TOWN AND COUNTRY PLANNING ACT 1990 NON MATERIAL AMENDMENT

Reference:	H12-0546-26	Date of Decision:	25th June 2026
Applicant:	Mr S Butler Sunindale Marriots Gate Lutton Spalding PE12 9HN		
Location:	Sunindale Marriots Gate Lutton Spalding		
Description:	Proposed dwelling and detached garage - approved under H12-0930-24. Modification to Condition 2 to allow amendments to previously approved plans and amendment to the wording of Condition 5 to remove the reference to the BNG enhancement area

Proposed Site Plan 1:500

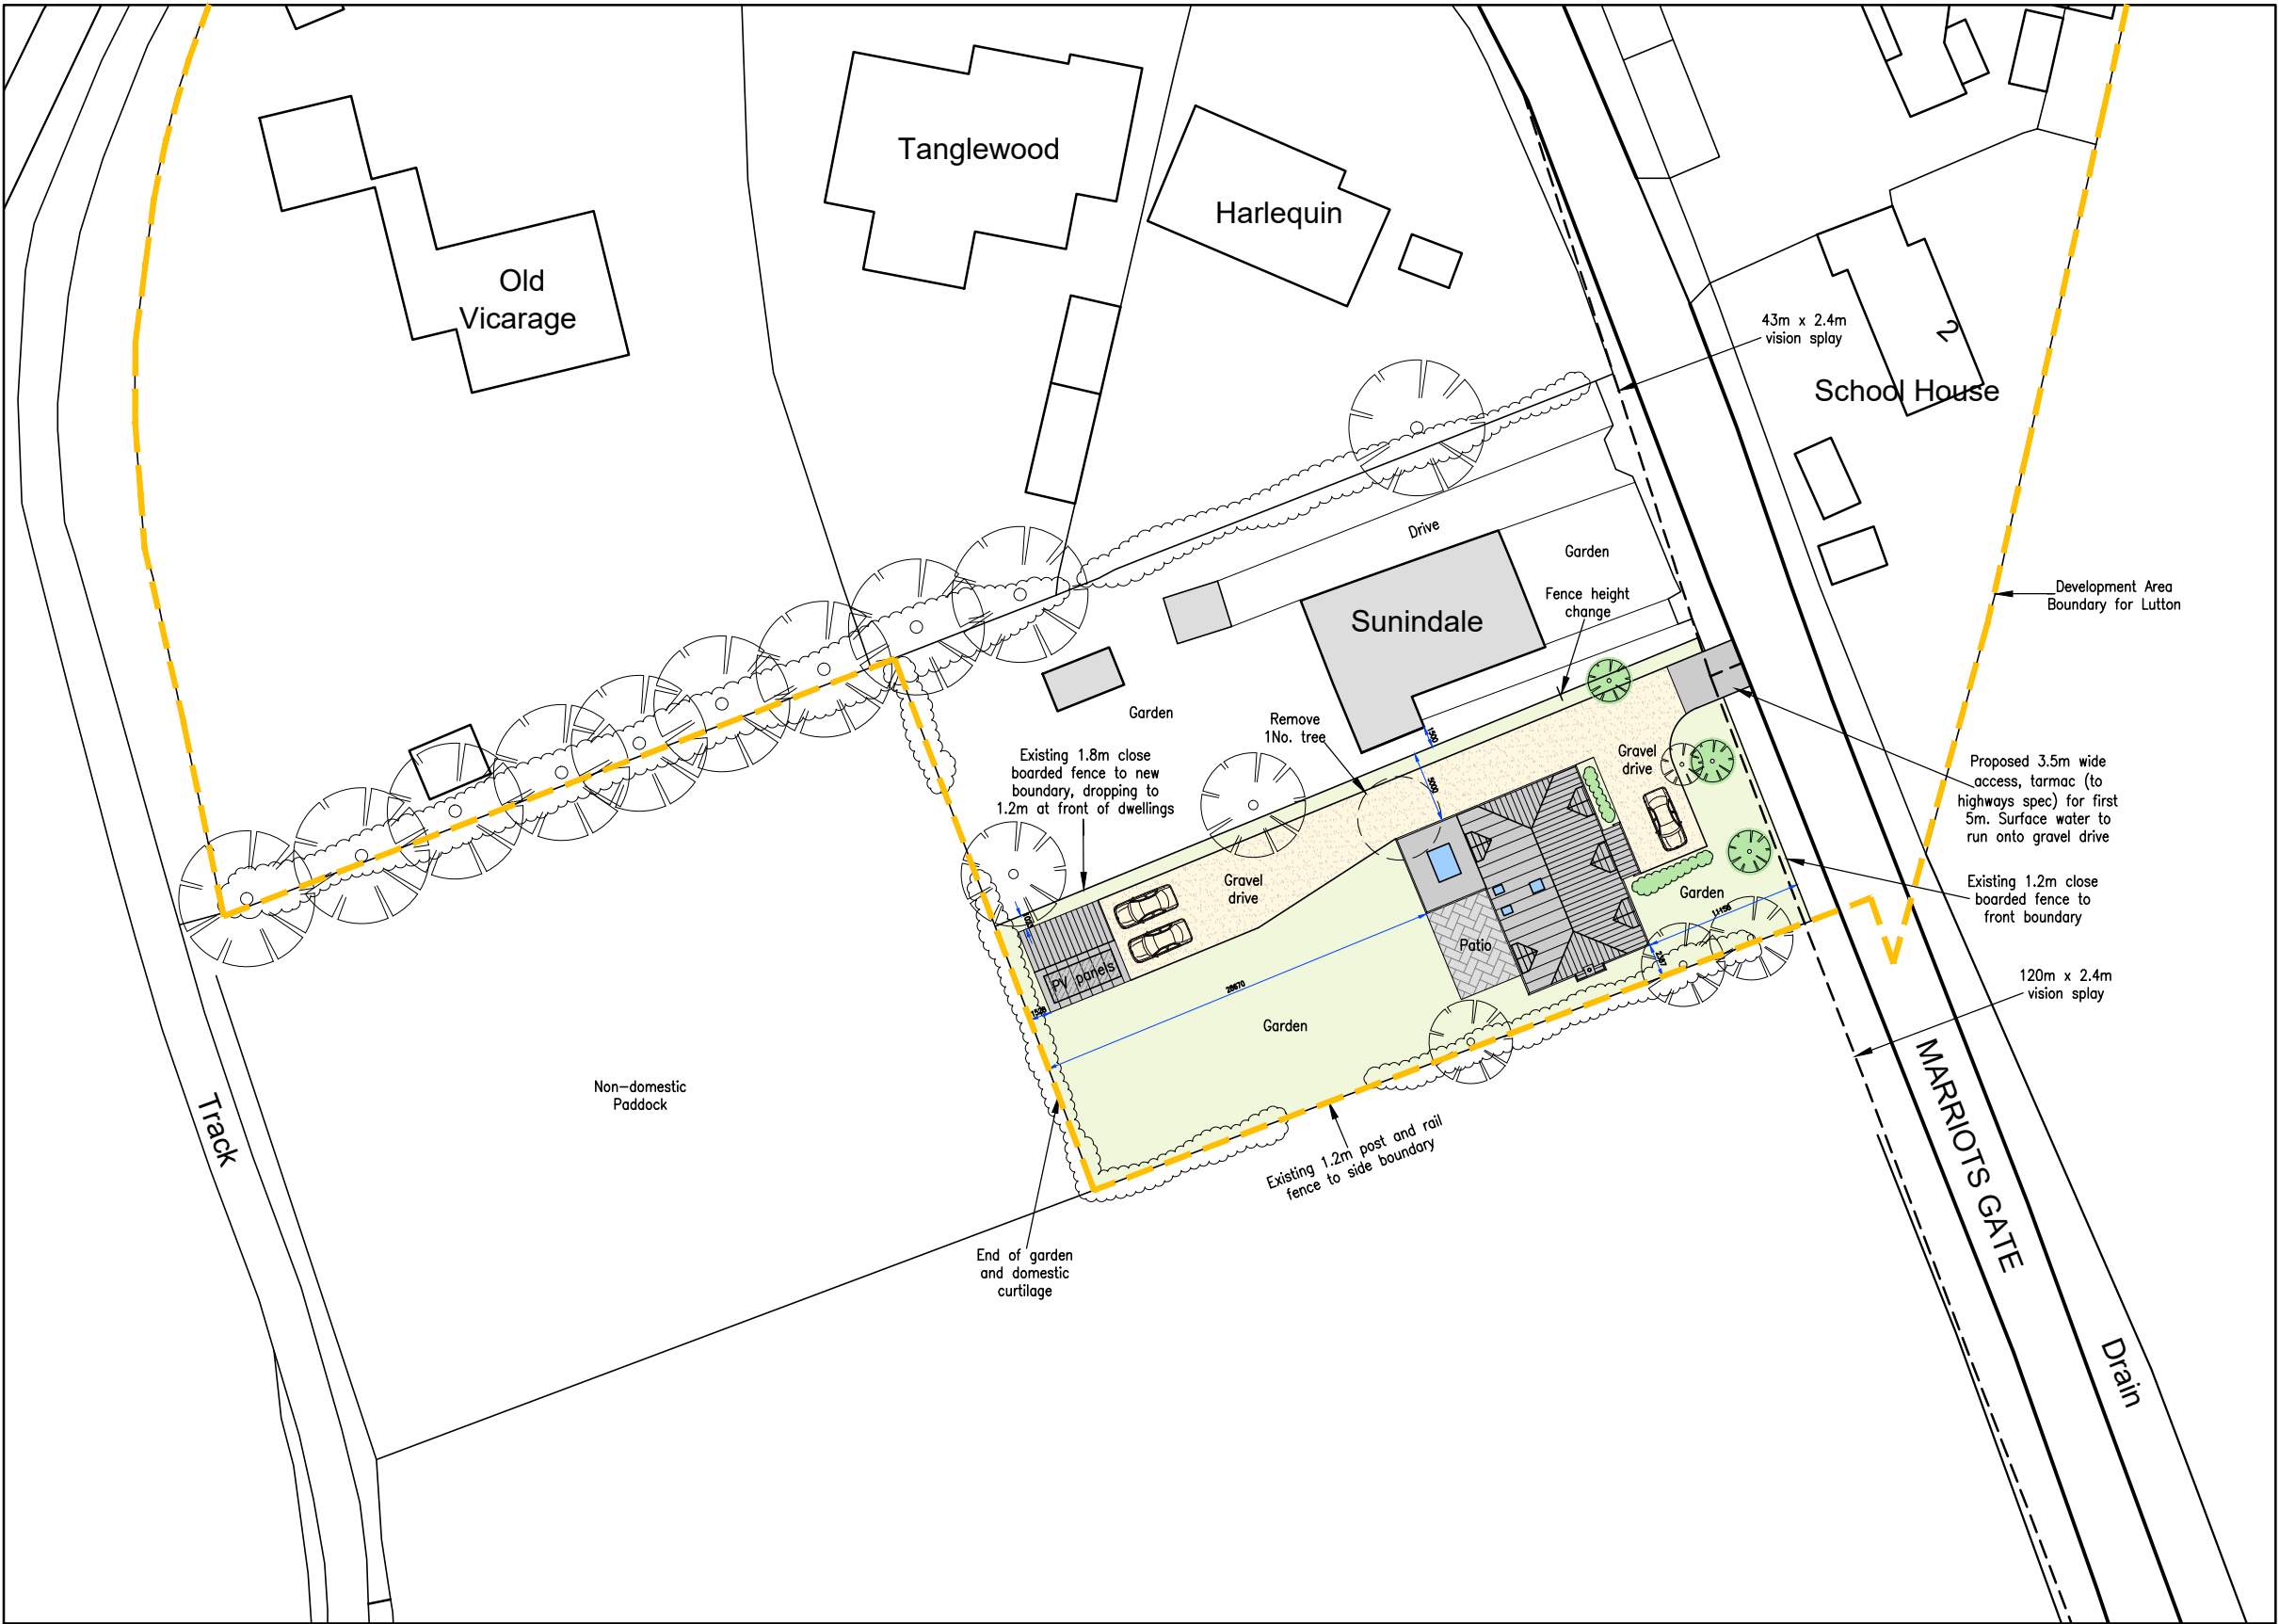
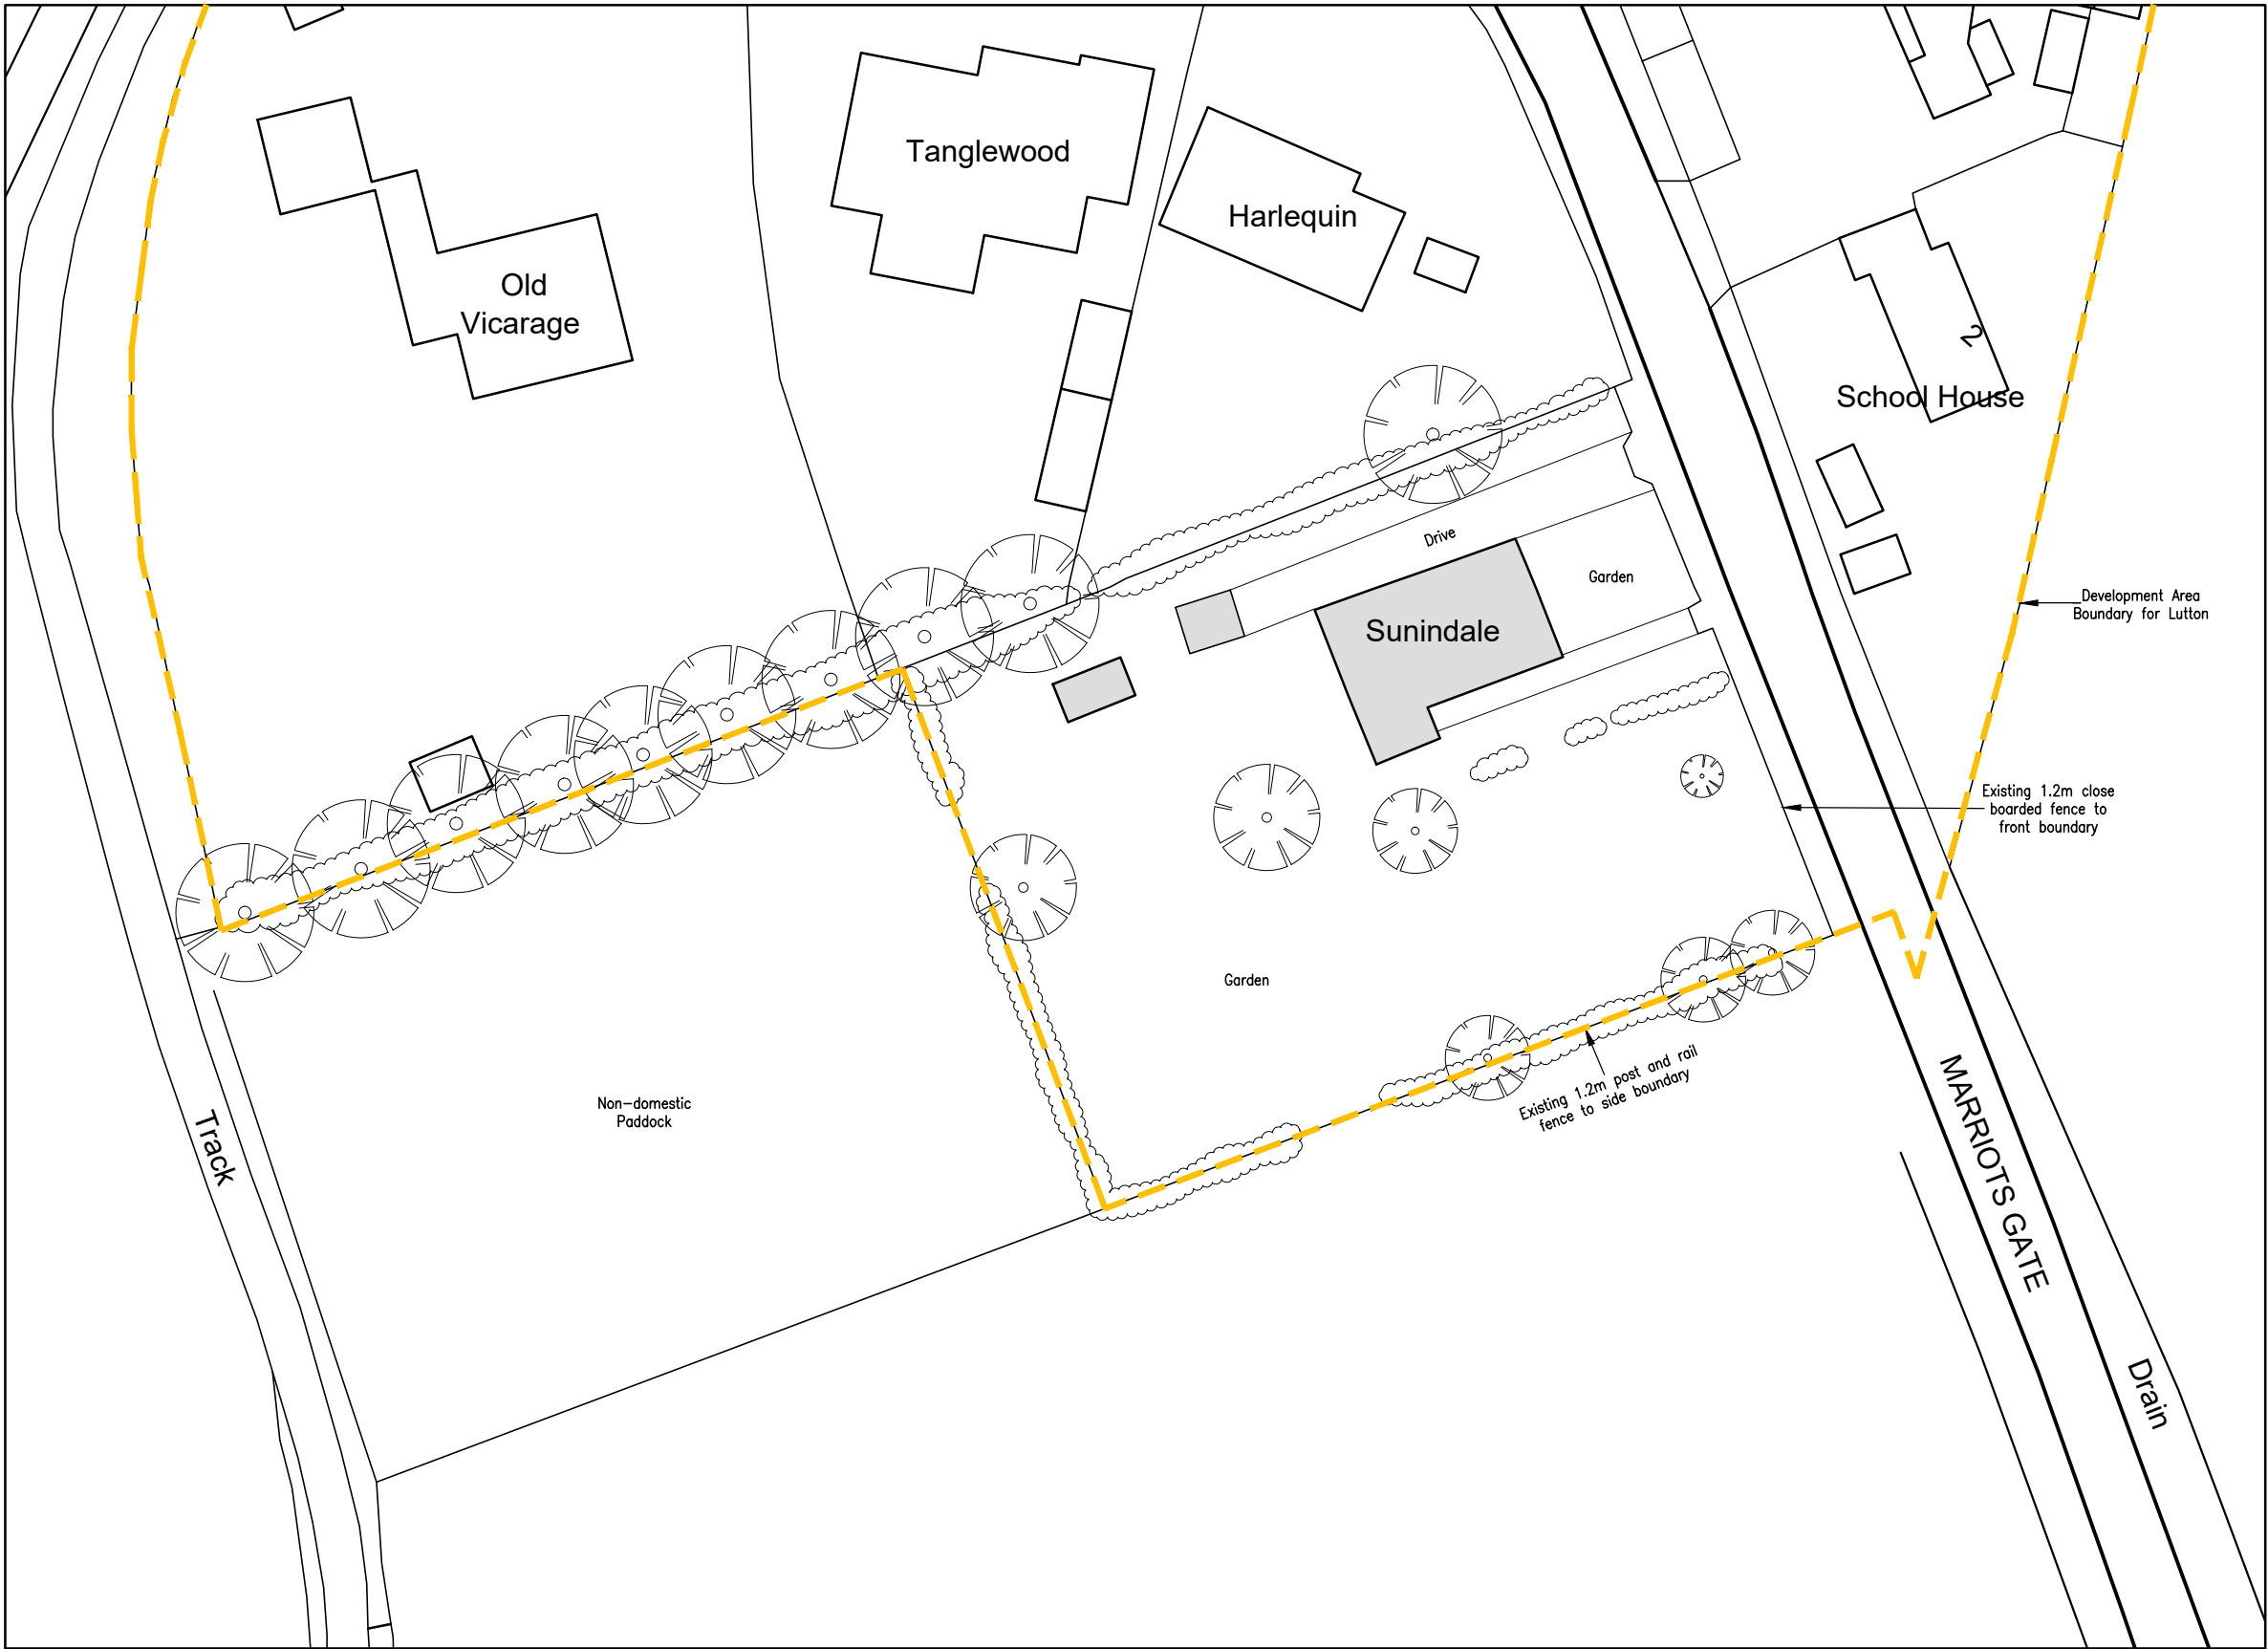
- 1 The proposed amendment, comprising the removal of the reference to what was formerly the Biodiversity Net Gain enhancement area, is not considered to materially affect the purpose of the conditions or the planning permission and is therefore acceptable. Condition 5 is amended as follows:

"The land which is located to the rear of the site (identified as an area which is outside the settlement boundary and is labelled as 'Non-domestic paddock' on the submitted site plan - 6965/02F), shall not be used as a residential garden.
